From: Zac Denton
Sent: 20 December 2018 08:43
To: Lynnyrd Wolfe
Subject: FW: Ep/166/18/hh
Attachments: 18075 DOYLE 100 Sea Road East Preston new-01R1 EXISTING A1.pdf; 18075 DOYLE 100 Sea Road East Preston new-02R3 PROPOSED A1.pdf

From: kathryn [REDACTED]
Sent: 14 December 2018 10:57
To: Zac Denton
Subject: Ep/166/18/hh

PROPOSED FLOOR
PLANS 1:50

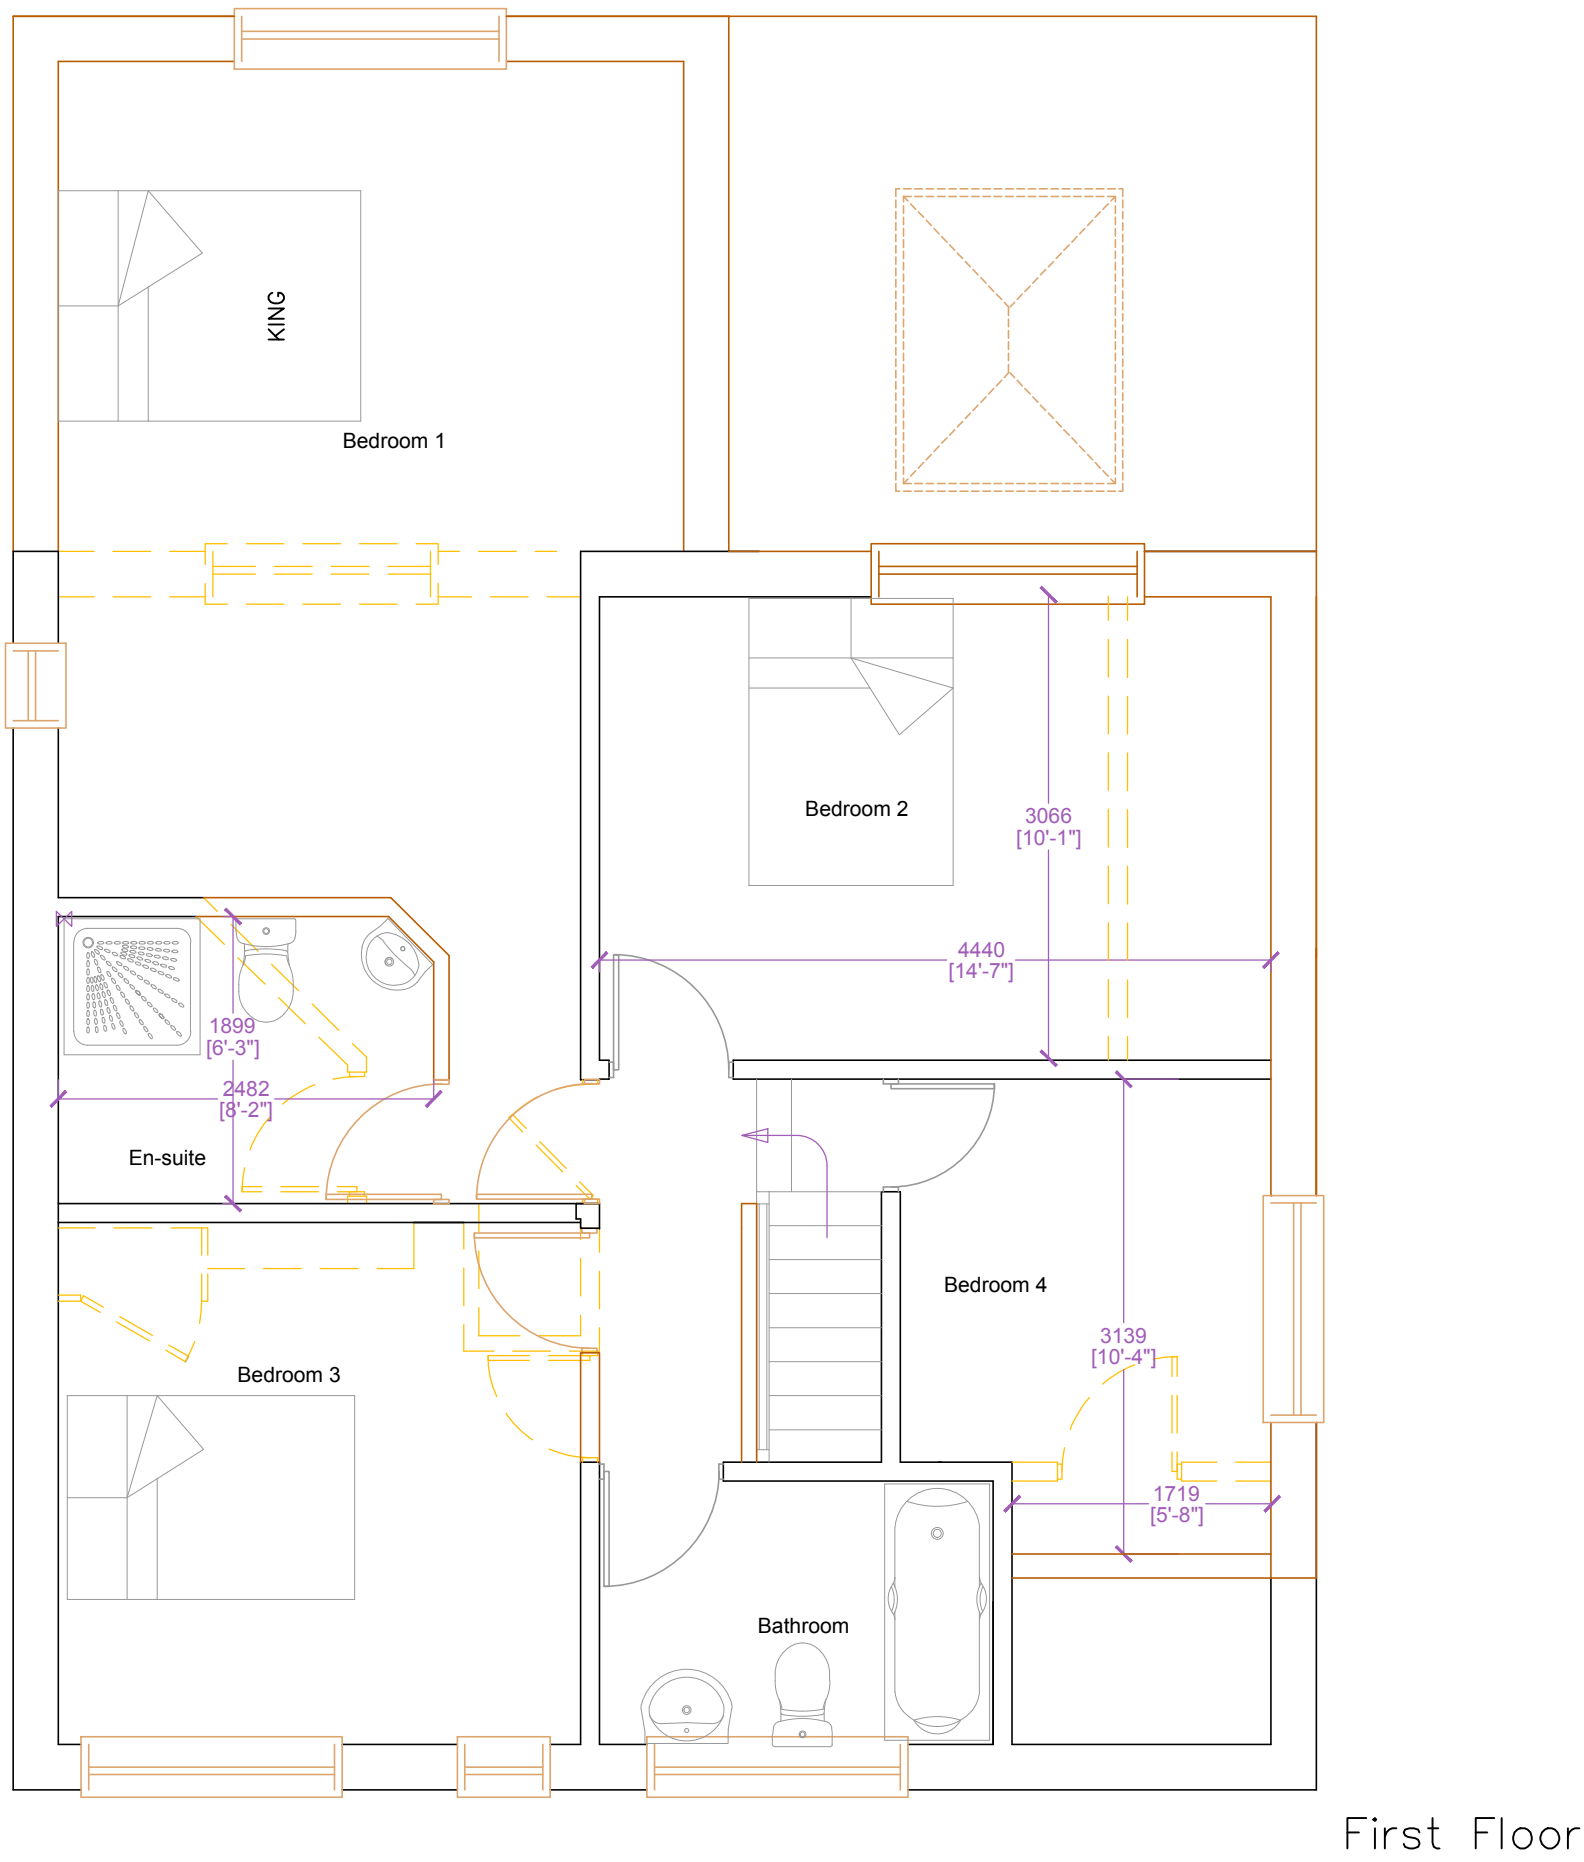
Further to our recent telephone conversation please find attached the amended plans detailing the change in labelling.

May I also take this opportunity to respond to comments from the neighbouring property at 102 Sea Road. The proposed 2 storey extension will as stated in the comments extend past the rear of the house by 3.5 m however this is no further than the existing conservatory extends within the garden of 100 Sea Road, or indeed various other conservatory/extension along that stretch of road. The proposal comfortably sits within the 45 degree rule for extensions such as these.

I would also like to alleviate the neighbours fears regarding overlooking and overshadowing; there are to be no overlooking windows on the Southern elevation of the proposal, equally due to the application site being set further North of 102 Sea Road, there won't be any issue of overshadowing. Their current dining area and utility room of 102 Sea Road can only ever be overshadowed by their own property.
